Percolation test and groundwater monitoring E...

Thomas Callaway <Thomas.Callaway@arun.gov.uk> 05/12/16 at 3:57 PM
To: 'Dick New'

EXISTING DRAINAGE FOR SAND SCHOOL - (1 NORTHFIELDS COTTES PO203

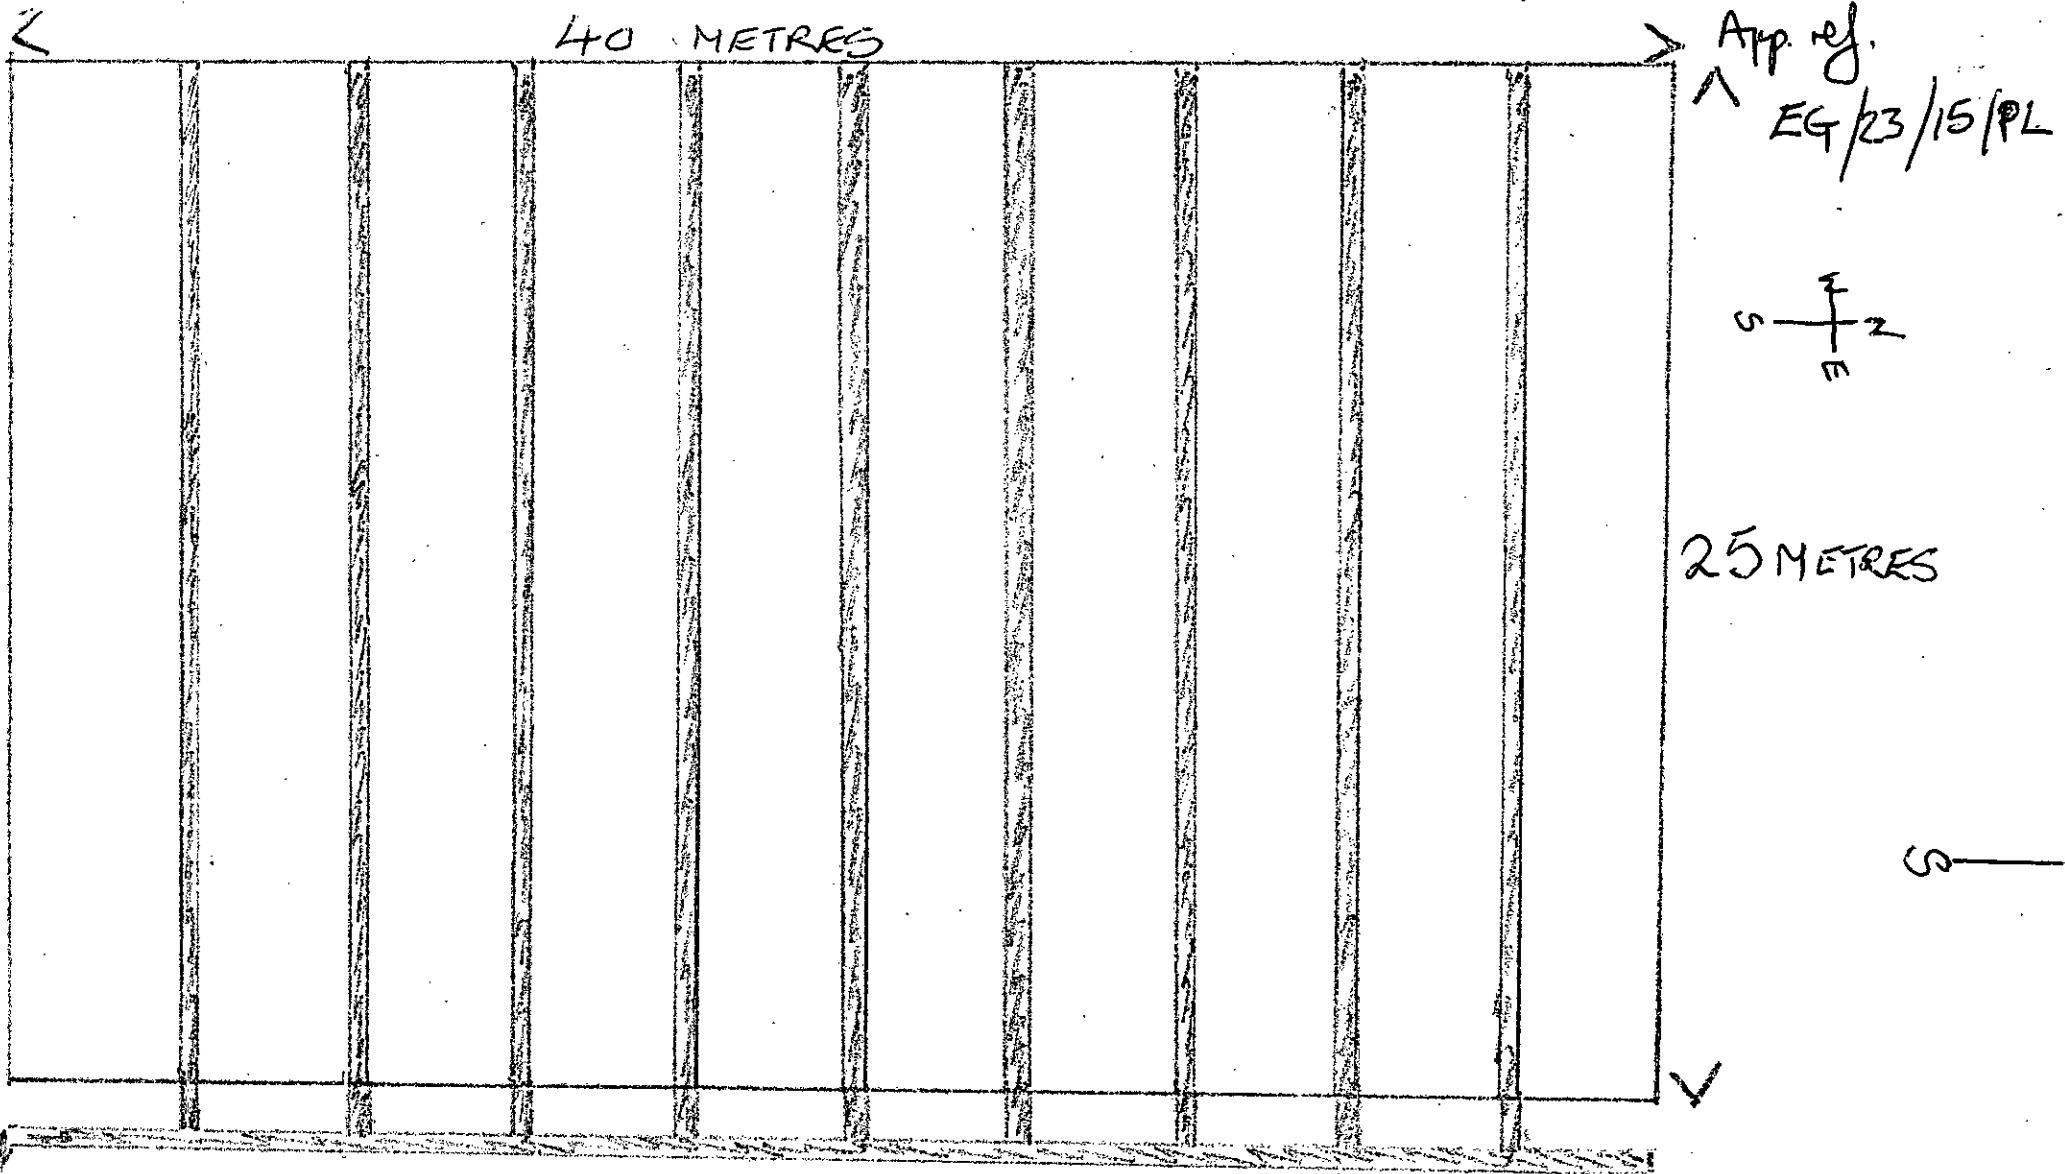
It would appear that the sand school drainage should be okay to take the surface water drainage from the redeveloped barn, with the overflow coming into use in times of high groundwater. I would recommend extending a run of French drain towards the barn for it to connect to.

The details would need to be submitted in a discharge of condition application which would then be forwarded to me by the planners for me to check and approve. This should include the percolation test results and layout drawing with any necessary amendments.
